Project Title: TOWNHOUSES FOR BUCHANAN Building Permit #: _____ City Drainage #: F14D074

Re: Townhouses for Buchanan
4622 12th Street N.W.
Traffic Circulation Layout
Engineer's/Architect's Stamp 09-13-16 (F14-D074)

Based upon the information provided in your submittal received 09-15-16, the above referenced plan cannot be approved for Building Permit until the following comments are addressed:

**CIVIL101**

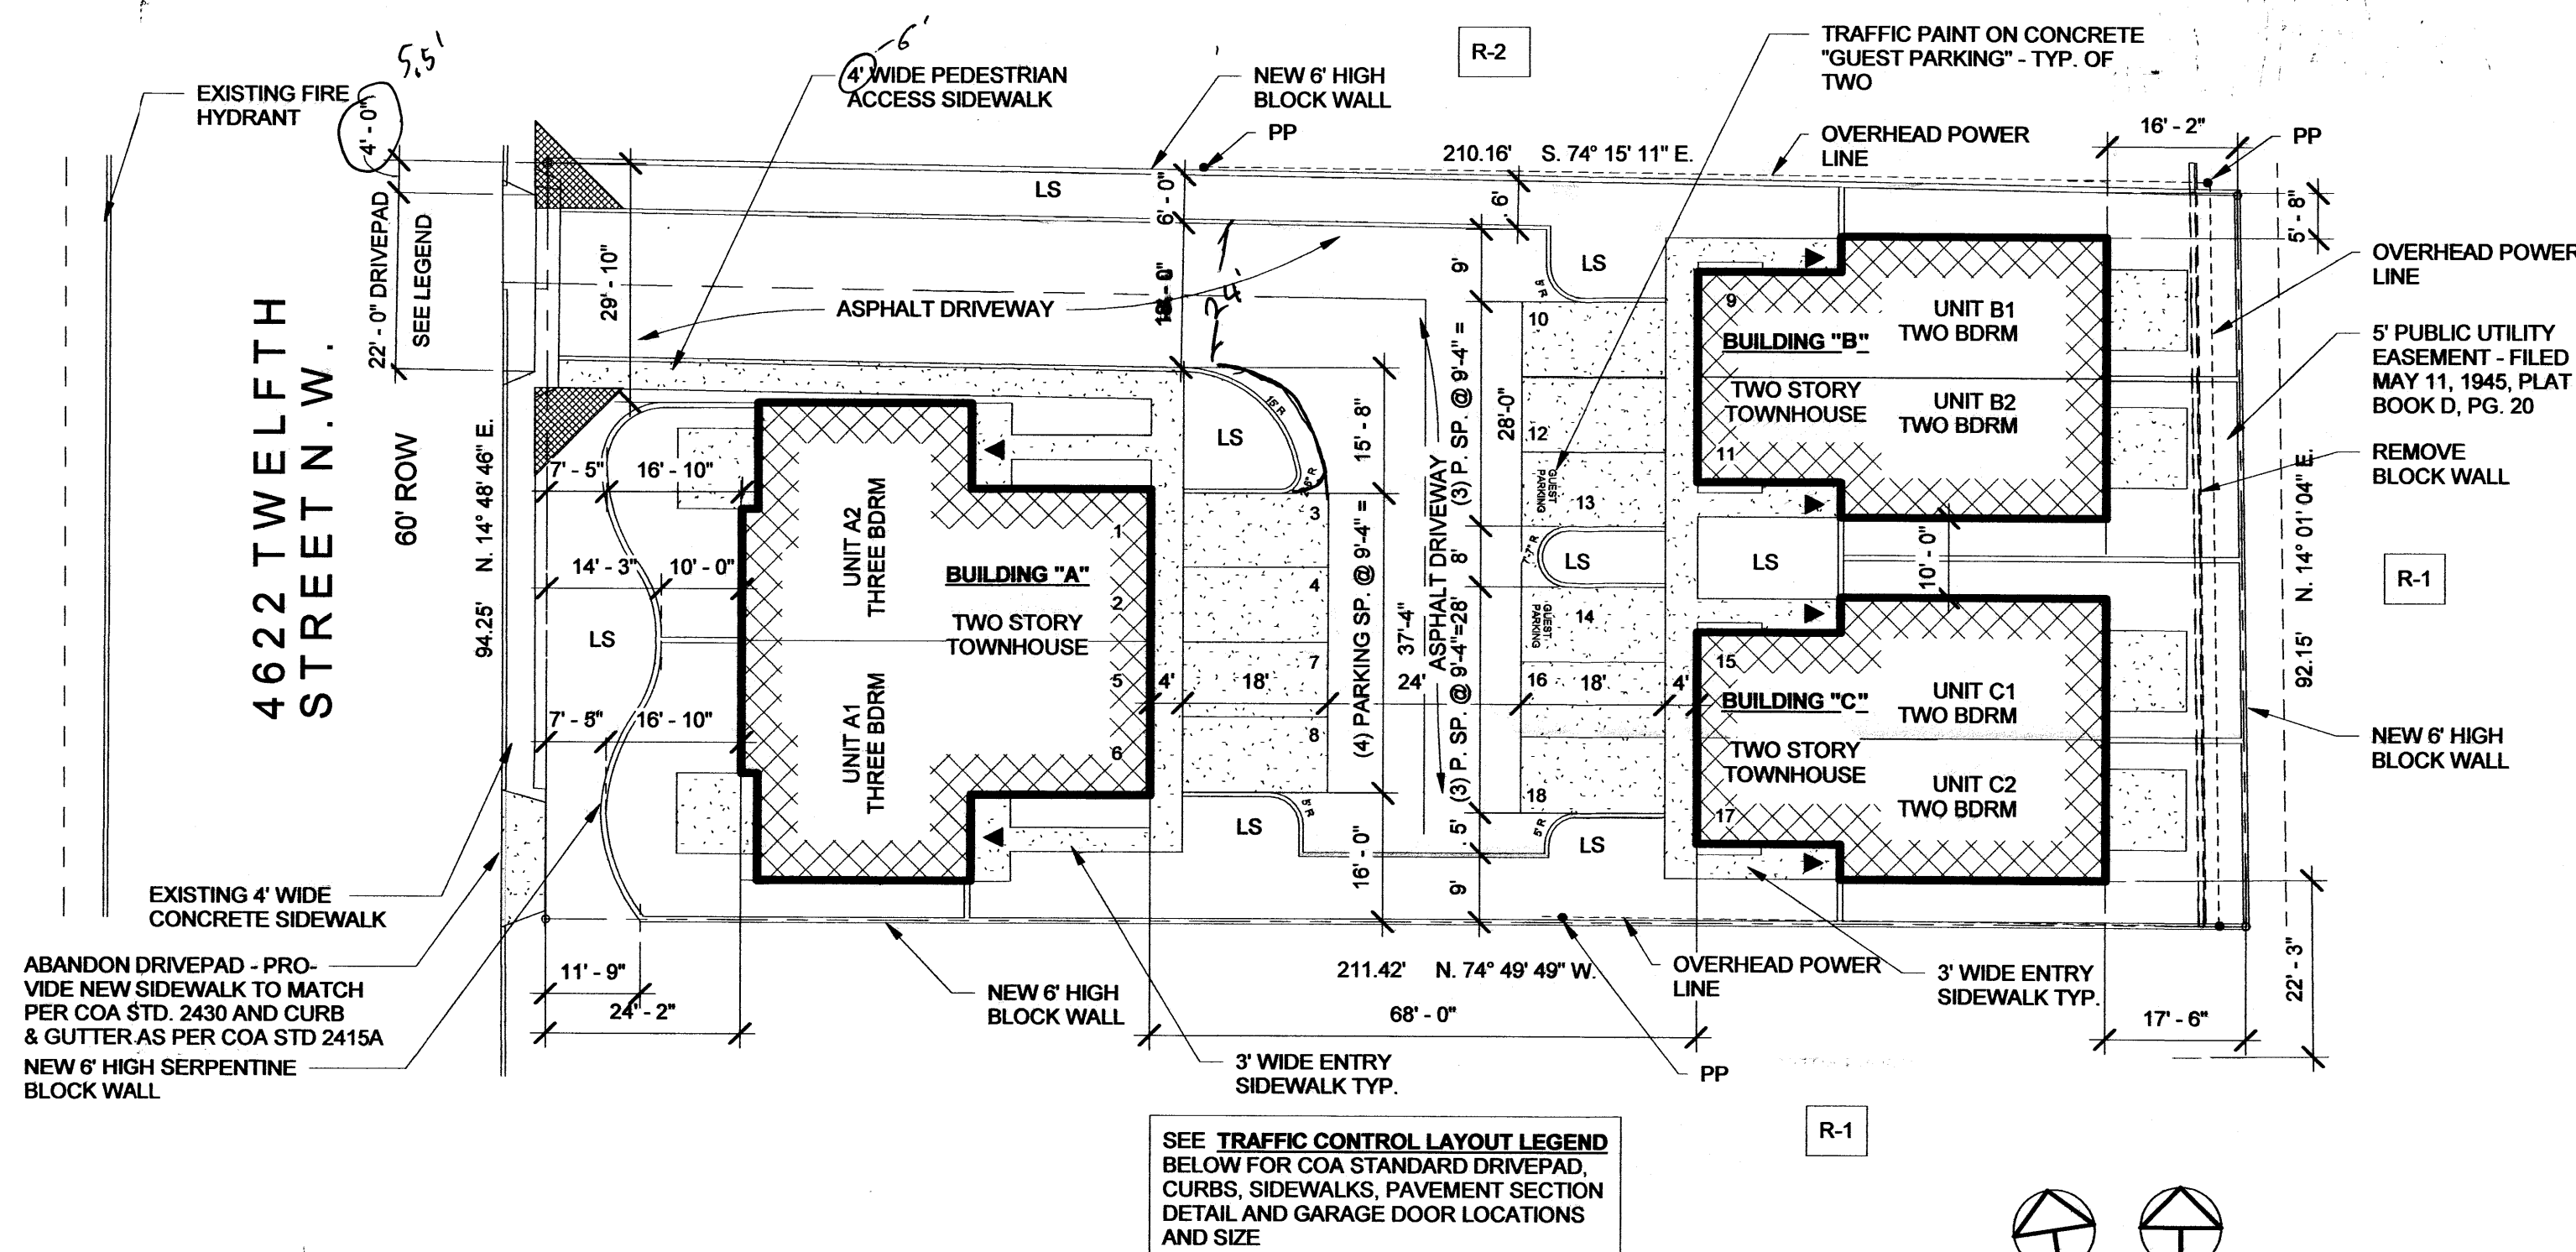
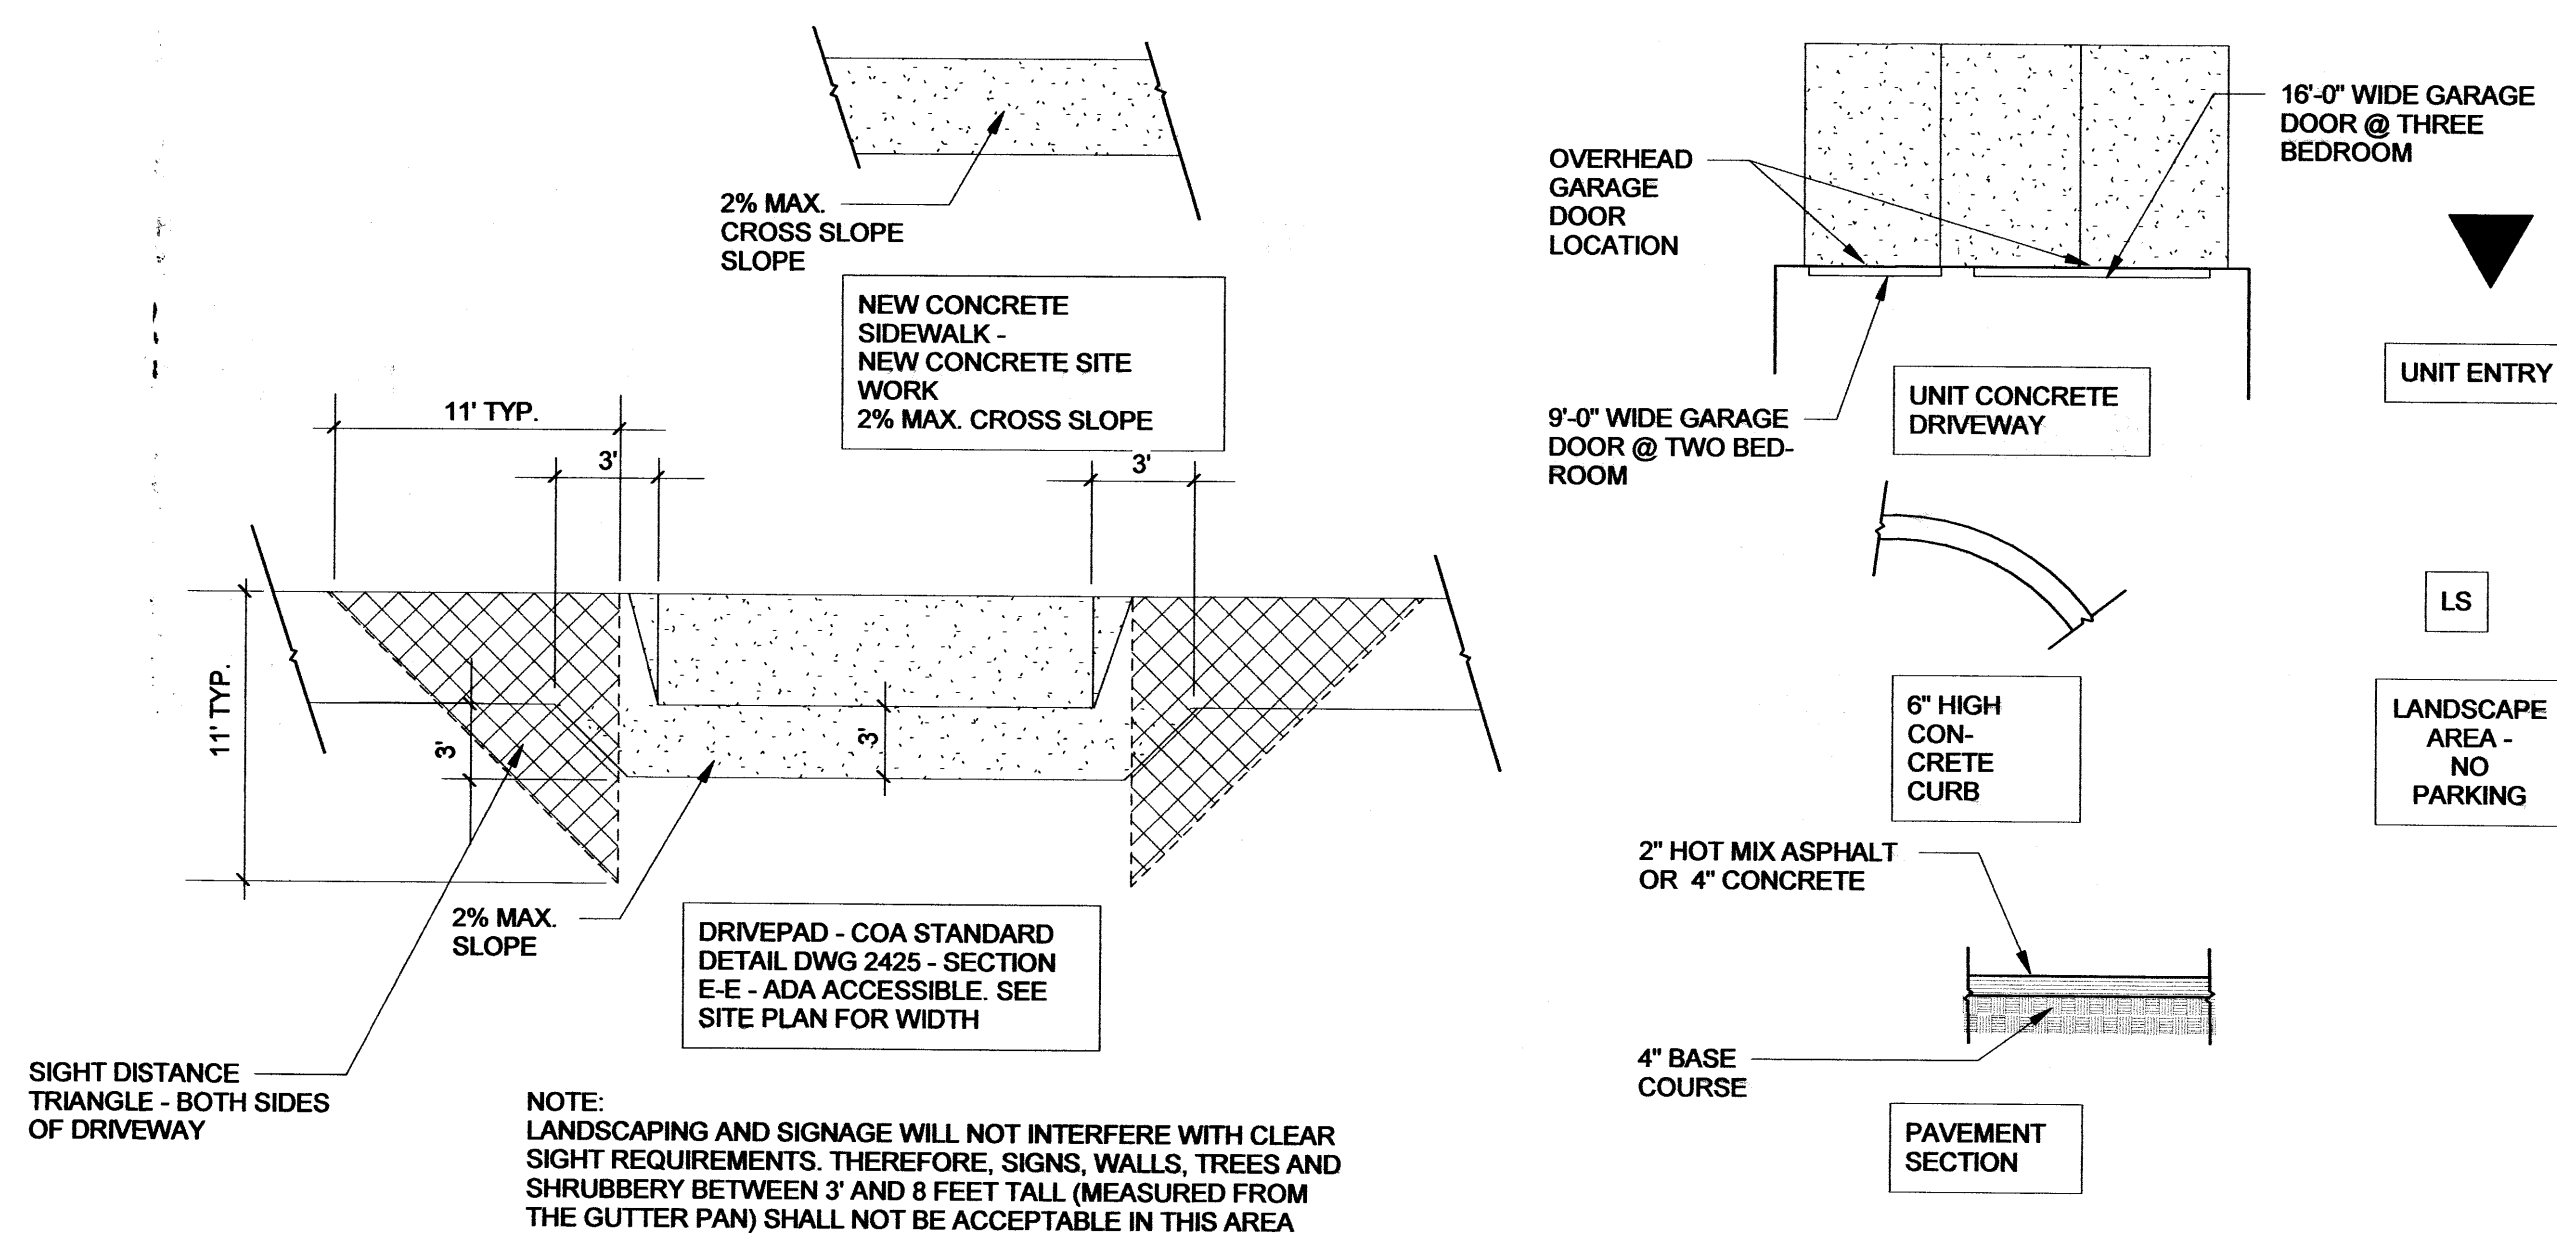
1. Identify the right of way width, and street widths on 12th Street.
2. Per the zoning code, a 6 ft. wide ADA accessible pedestrian pathway is required from the public sidewalk to the building entrances. Please clearly show this pathway and provide details. This path should extend to the two bedroom units as well.
3. Service vehicle and/or refuse vehicle maneuvering must be contained on-site; provide a copy of refuse approval.
4. If the drive pad is to be located closer than 5.5' from the property line, a letter of concurrence signed by the neighbor affected is required. Also, the width and location of the neighbors drive is needed.
5. The radius on the bum-out should extend to the end of the parking stall.
6. See Chapter 23, Section 6 of the City of Albuquerque *Development Process Manual*, for appropriate drive pad widths.
